DEVELOPMENT HEARING OFFICER

PR-2023-008197

SD-2024-00070 – PRELIMINARY/FINAL PLAT

LAND DEVELOPMENT PLANNING | DANNY MARTINEZ agent for **ROY & EMMA LUNA** requests the aforementioned action(s) for all or a portion of: **LOT 90-A and LOT 90-B, UNIT 3, ALVARADO GARDENS** zoned **R-A, located at 2733 CANDELARIA RD NW** between **CANDELARIA RD NW and TRELIS DR NW** containing approximately **0.5806** acre(s). (G-12)

Minor Preliminary/Final Plat Replat Lot Line Adjustment Between Lot 90-A and Lot 90-B Alvarado Gardens, Unit 3 Projected Section 1, T 10 N, R 2 E, NMPM Town of Albuquerque Land Grant City of Albuquerque Bernalillo County, New Mexico

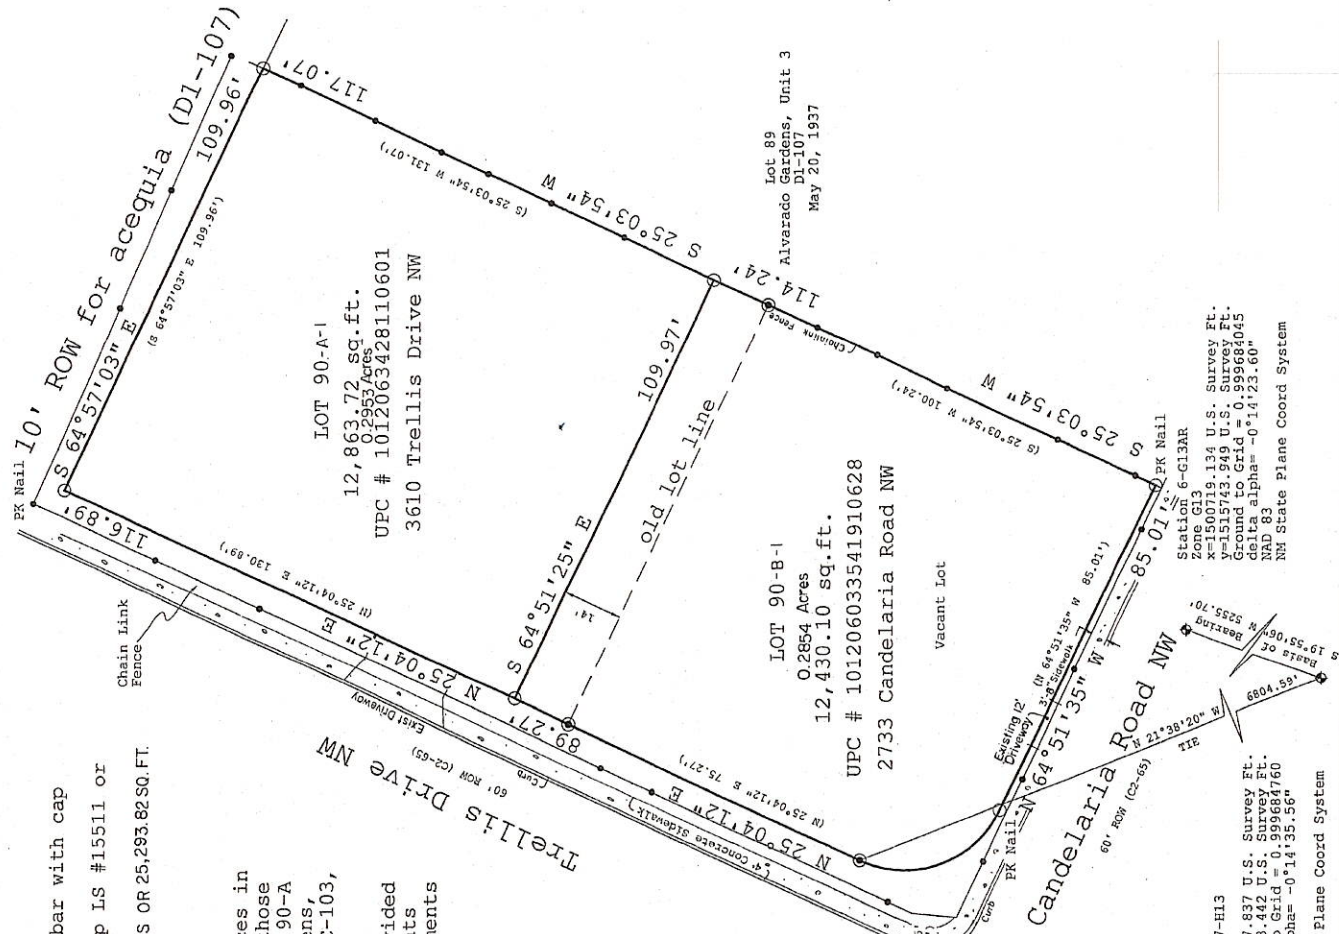
Confirm that the driveway will reach the 20' minimum and annotate size on the plat

Current requirements needed are a 5' sidewalk width. Plans show a 3.8'-4' sidewalk width. A determination request was submitted regarding the landscape buffer and sidewalk requirements. Planning defers to transportation for review.

- The project and application numbers must be added to the Plat.
- Please confirm that an infrastructure list is not required for this project.
- Prior to final sign-off of the plat, the AGIS office must approve the DXF file and proof of approval must be provided.
- The date of the DHO approval shall be recorded on the Plat, per 6-6(K)(2)(k) of the IDO.
- After DHO approval and final sign off, a recorded copy of the plat must be sent to Jay Rodenbeck at jrodenbeck@cabq.gov and Angela Gomez at agomez@cabq.gov.
- Any granted waiver/determinations must be noted on the plat
